From: Critchley Architecture and Design [REDACTED]
Sent: 20 February 2019 13:15
To: Charlotte Easton
Cc: debi williams
Subject: R7/19/CLP - 9 Hawke Close, Rustington
Attachments: 18109_401F Sub.pdf; 18109_501F Sub.pdf; PD Rules.pdf

Further to your email of 7th February, please find attached updated plans and elevations. Please can you accept this as substitute drawings to the application?

Scale A1=1:50, A3=1:100
Drawn JHL/SAR
Date 27/11/18
18109-501 F

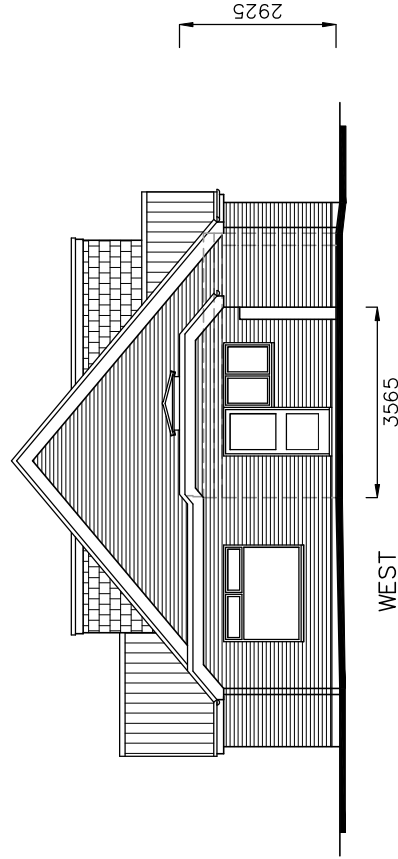
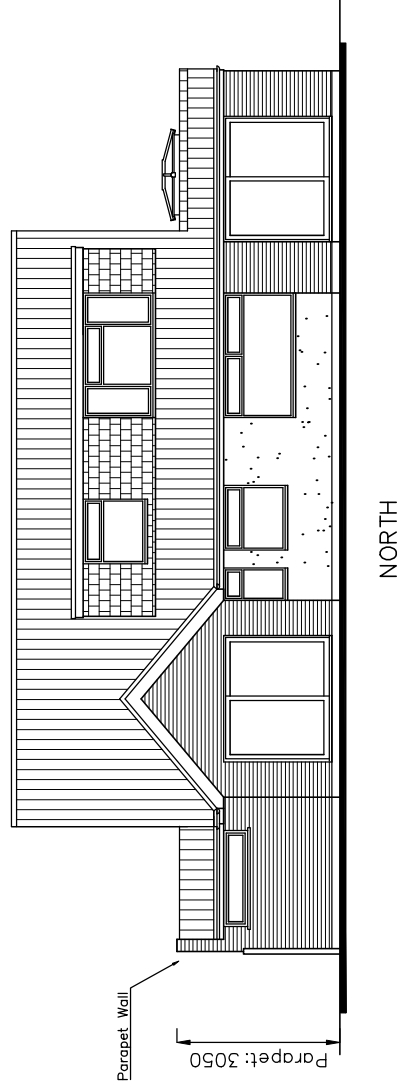
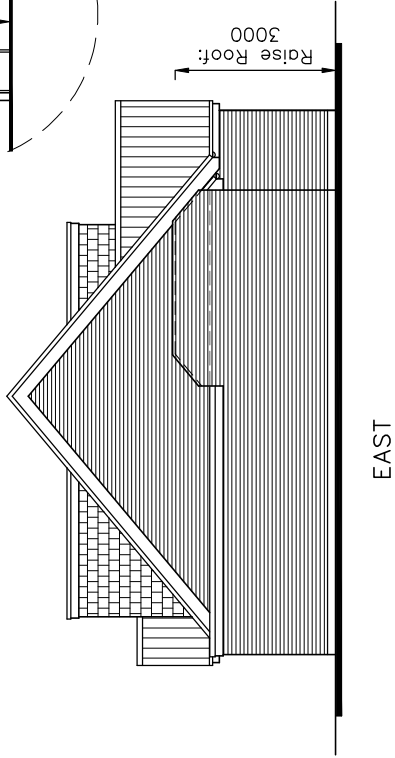
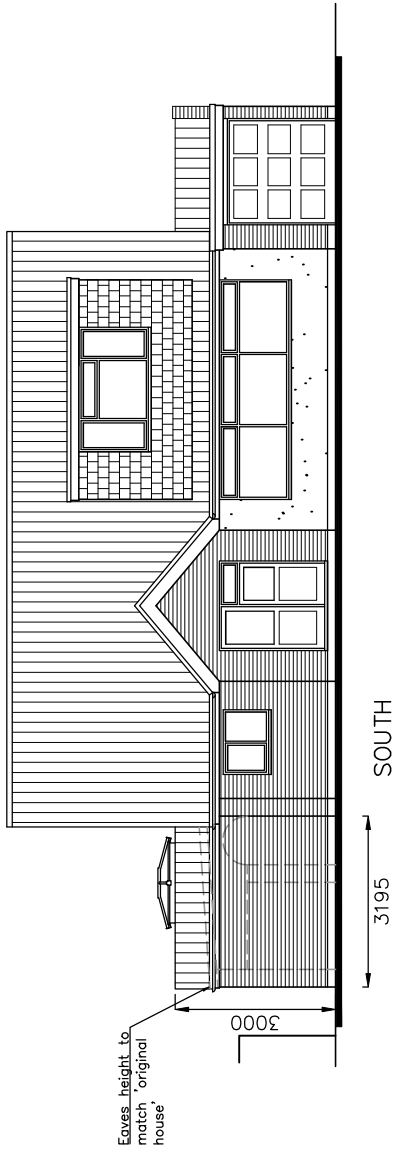
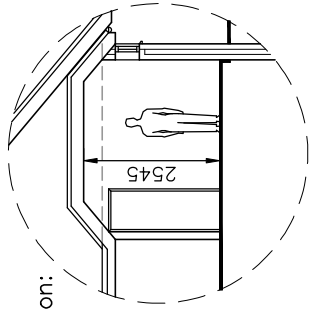
We have amended the rear extension (wet room) which we believe now falls under Permitted Development (eaves to match existing), and we wish to continue to obtain the Lawful Development Certificate for the attached plans.

18109-401

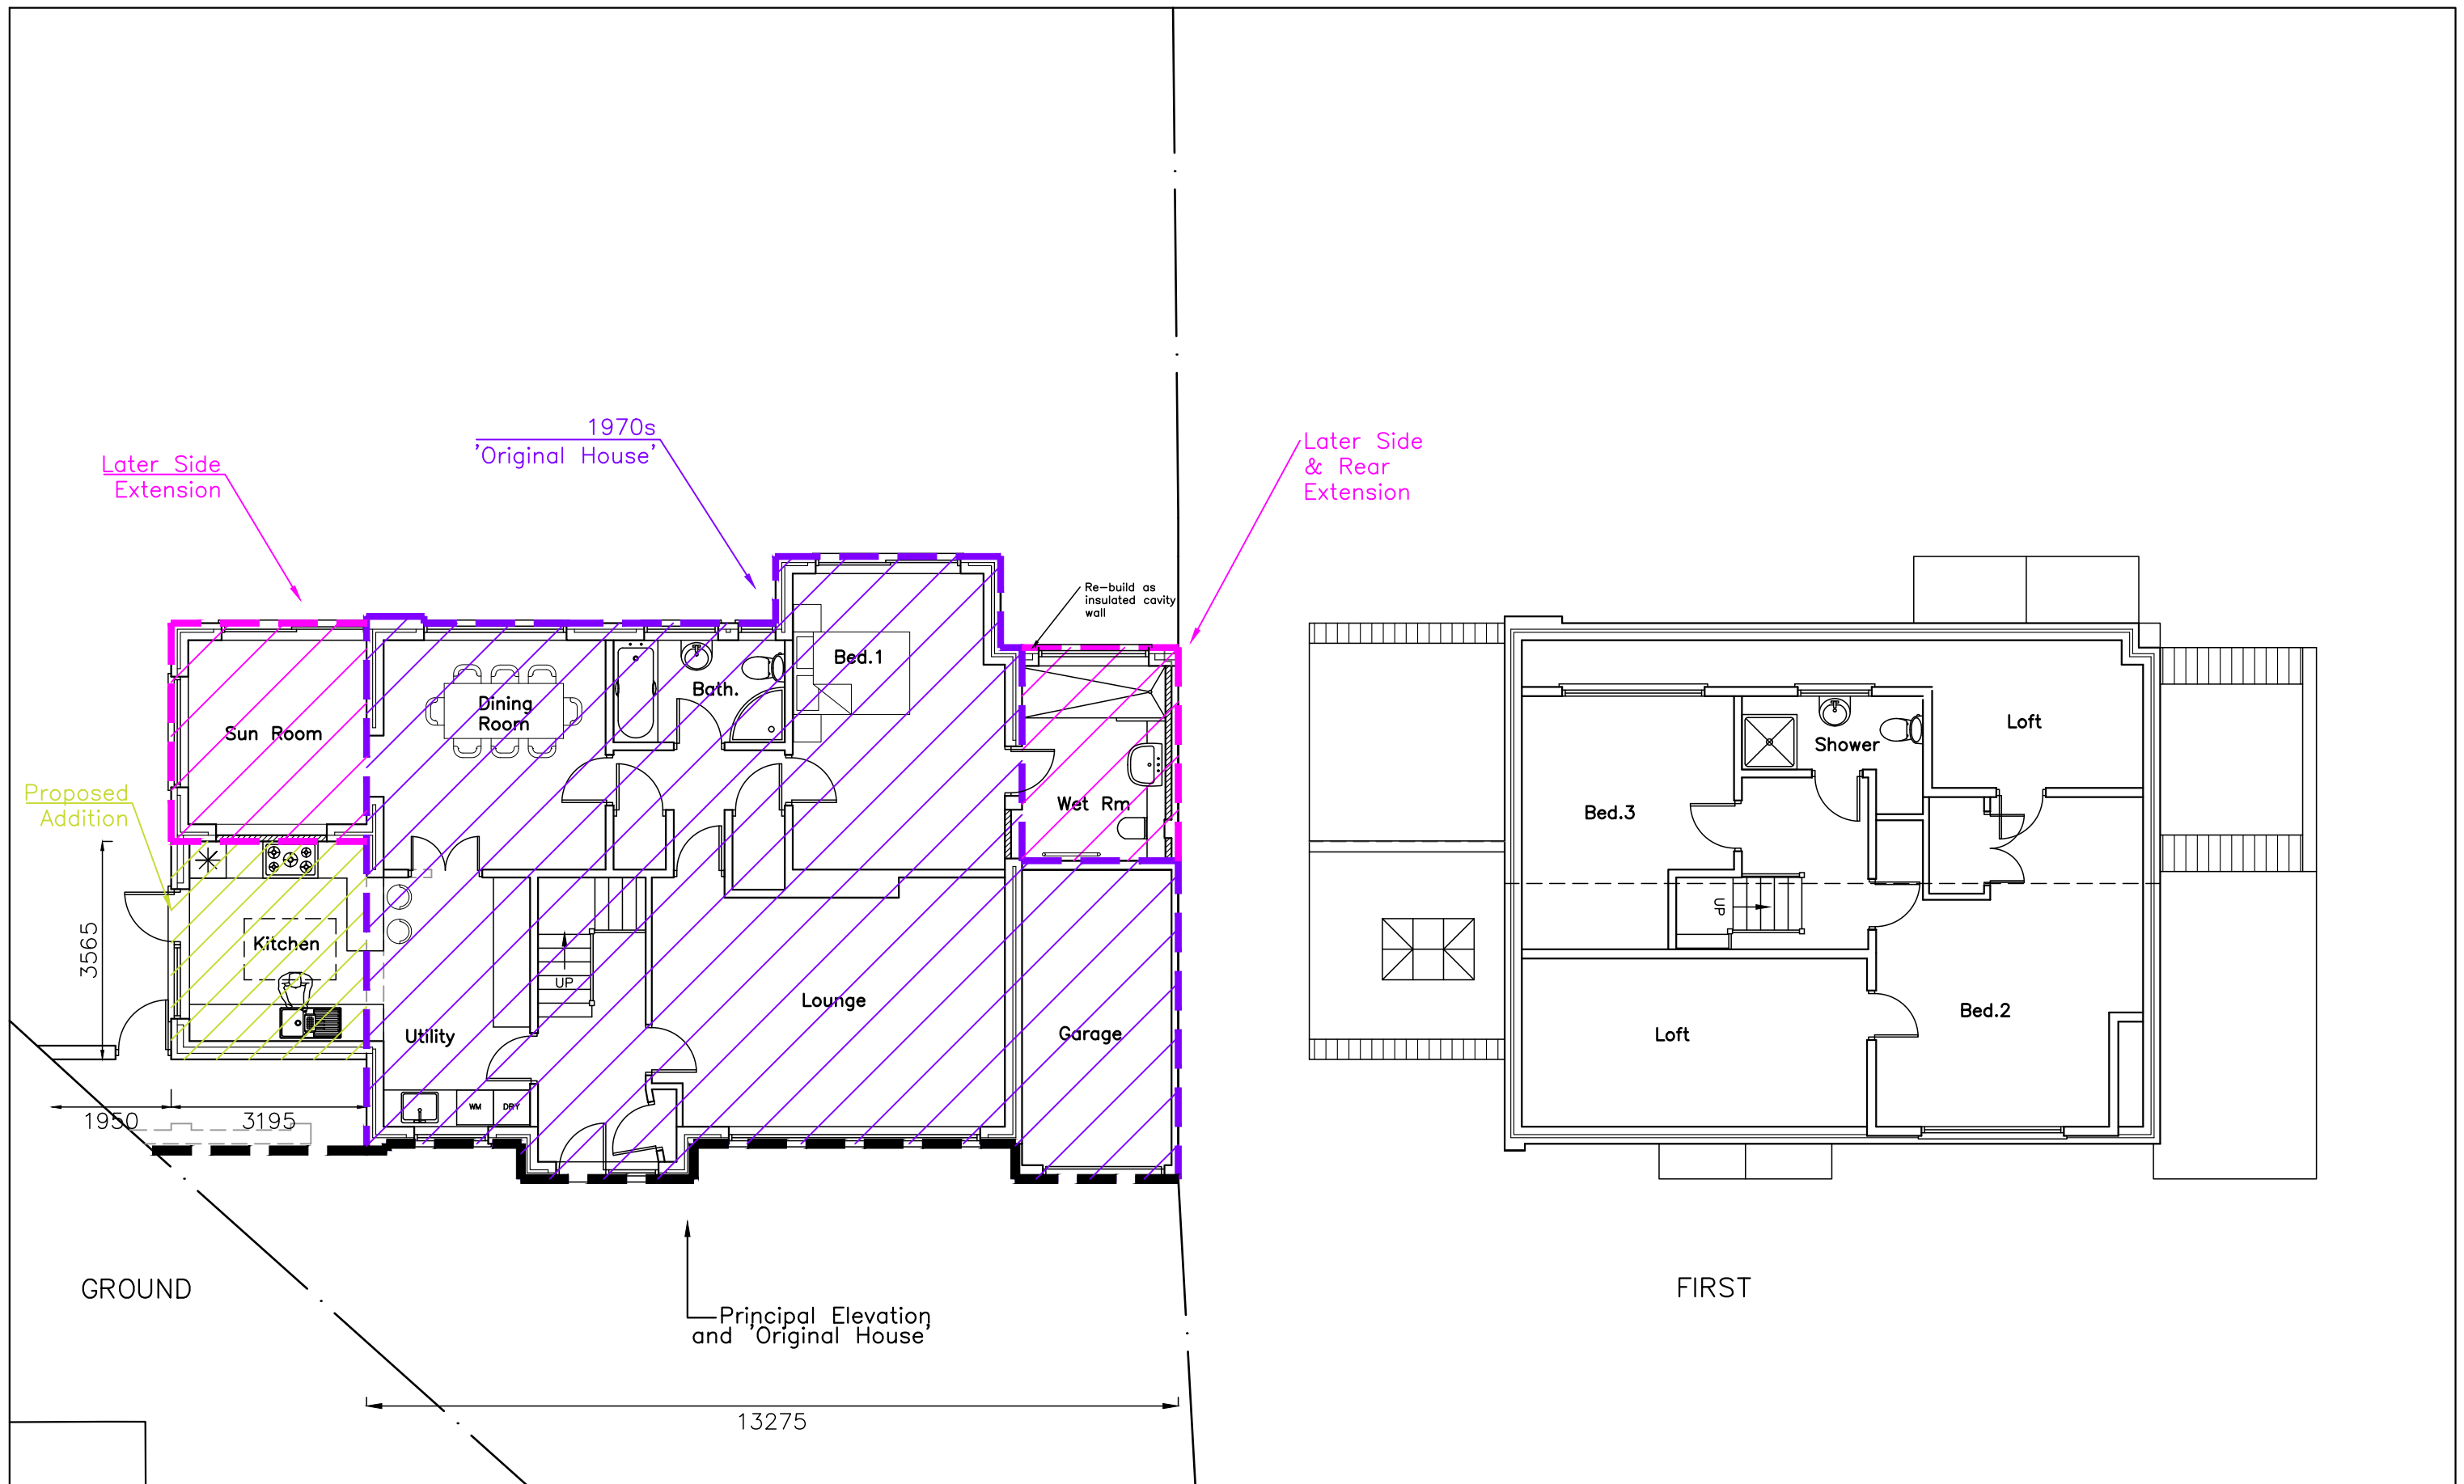
We have annotated the proposed plan (in the style of the PD Technical Guidance (Communities and Local Government)) for clarity to show that the proposed side extension does not extend beyond the principal elevation.
